*Erosion Control Team
600 East Fourth Street
Charlotte, N C 28202-2844*

Rezoning Petition Review

Date of Review: August 30, 2021

Rezoning Petition #: 21-161

**Rezoning Site Plan**

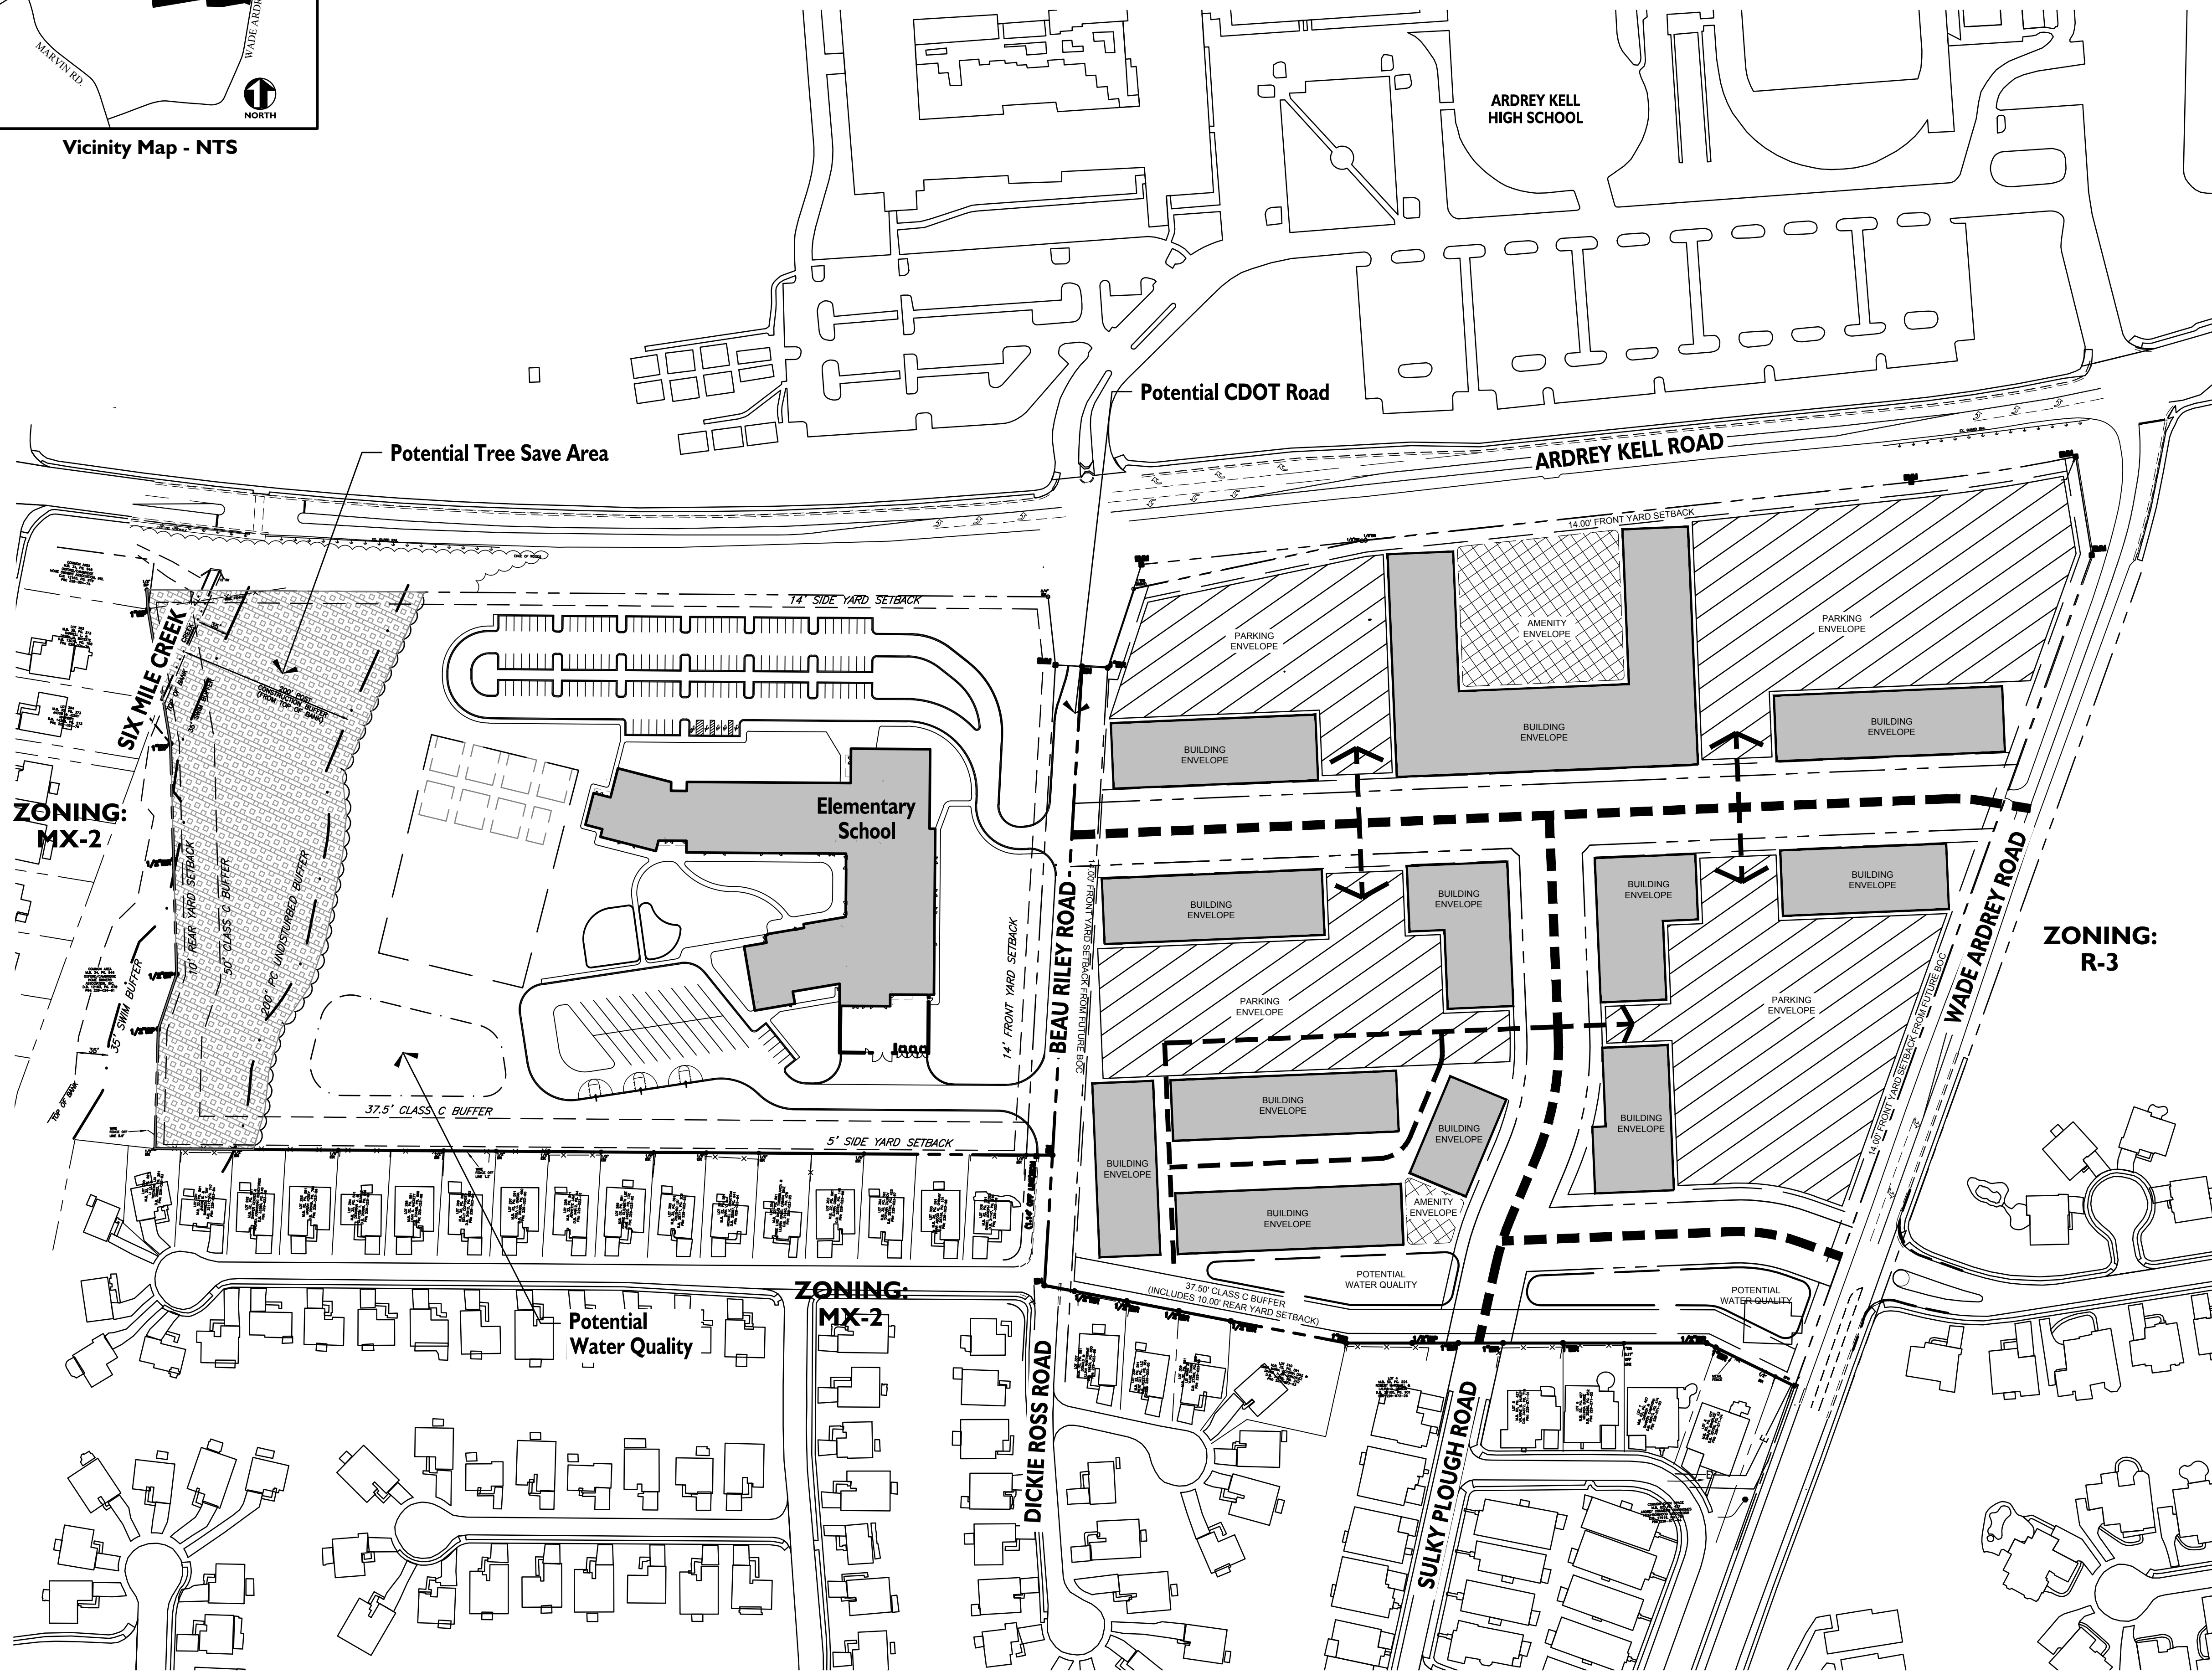
Drainage/Stormwater Management: Stream/wetland survey required prior to approval of civil site plan to ensure accurate delineation of top-of-bank/stream buffers/creek path and identification of any protected wetlands that may be on the site.
